From: Michael Flory
Sent: Monday, September 21, 2015 10:43 AM
To: 'Jim Miller'
Cc: Lindsey Ozbolt; 'Dave Heric'
Subject: RE: VA-15-00001 Heric Variance Comments

From: Lindsey Ozbolt [<mailto:lindsey.ozbolt@co.kittitas.wa.us>]
Sent: Thursday, September 17, 2015 12:21 PM
To: jbt@fairpoint.net; daveheric@outlook.com
Subject: VA-15-00001 Heric Variance Comments

Attached are the comments received during the comment period for the Heric Setback Zoning Variance. Please let me know if you have any questions or comments regarding these comments as the permit decision will be based in part on these comments.

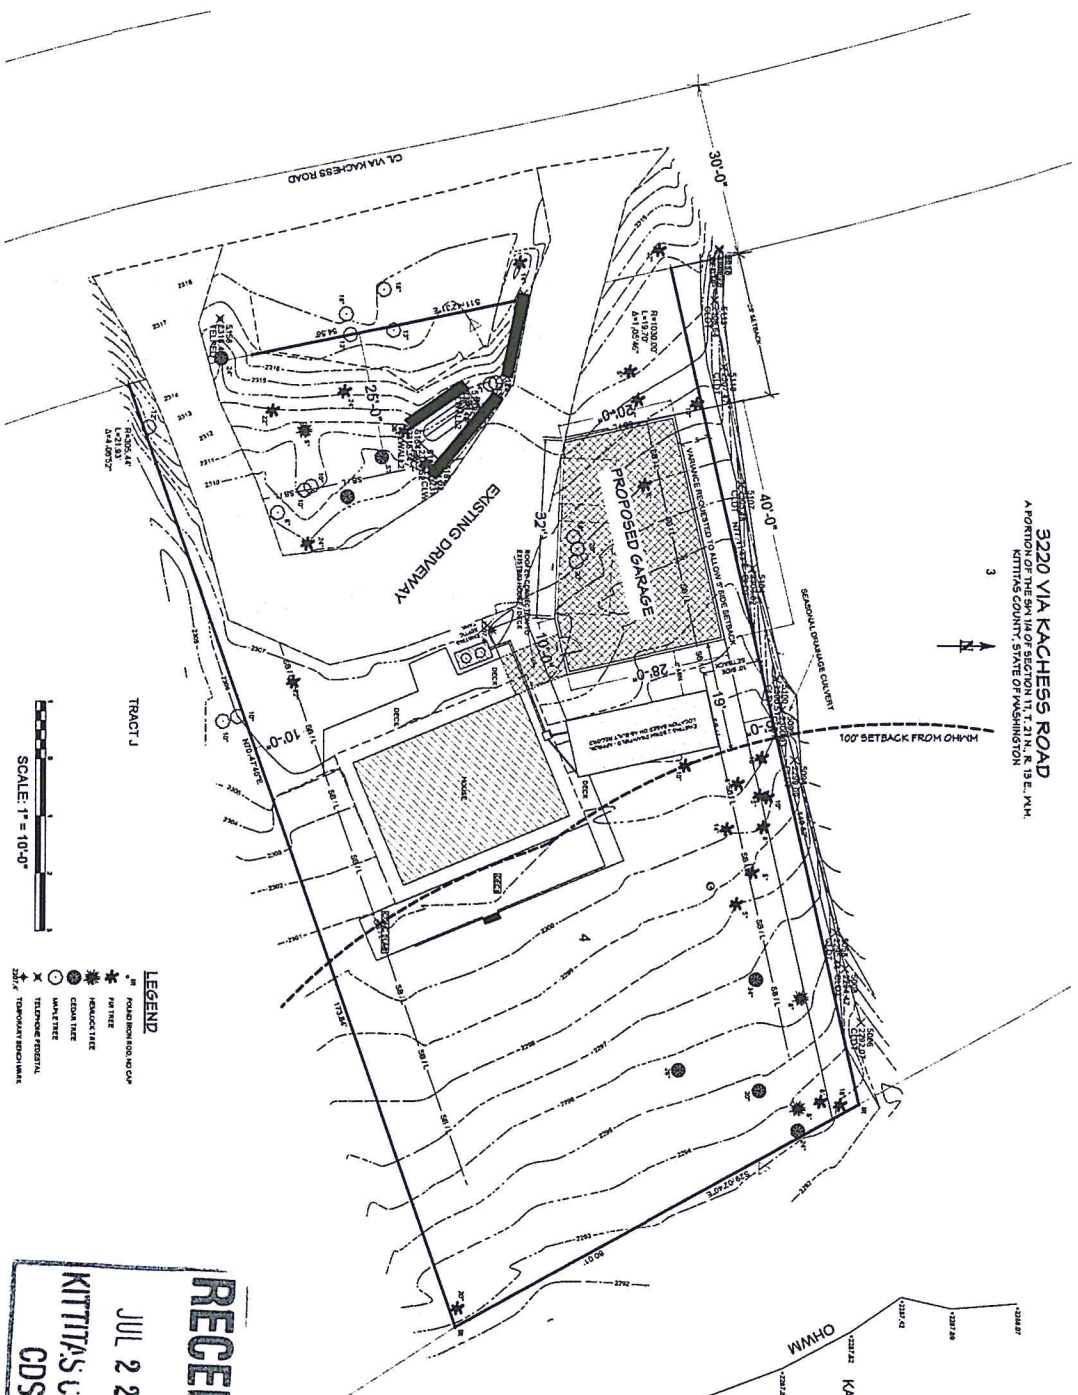
I sure wish I could help but I can't suggest a method of retaining or redirecting the snow and snow melt. It's a very large plane of roof that could create an awful lot of water during a thaw. My only comment to the Planning Dept. is that snow and runoff should be kept on the subject property. It would be of concern to create a situation that could potentially adversely affect the neighboring property. The Planning Dept. may or may not consider my comments in the decision.

The issue was snow and snow melt drainage affecting the neighboring property. Ideally, keeping all snow and water on the subject property is the concern.

This proposed roof slope and direction will help keep runoff on the subject property.

Hi Mike, There is a seasonal drainage on the side property line (between the building and the neighbor to the north). My thought was to create a shallow single-pitch metal roof (2/12 pitch) with snow brakes or a comp roof with 3/12 pitch to allow a slow release of the melt water toward the drainage (side property line). If that sounds acceptable I can work on a roof plan showing that. If that isn't okay...just let me know and I'll work on an alternative roof form.
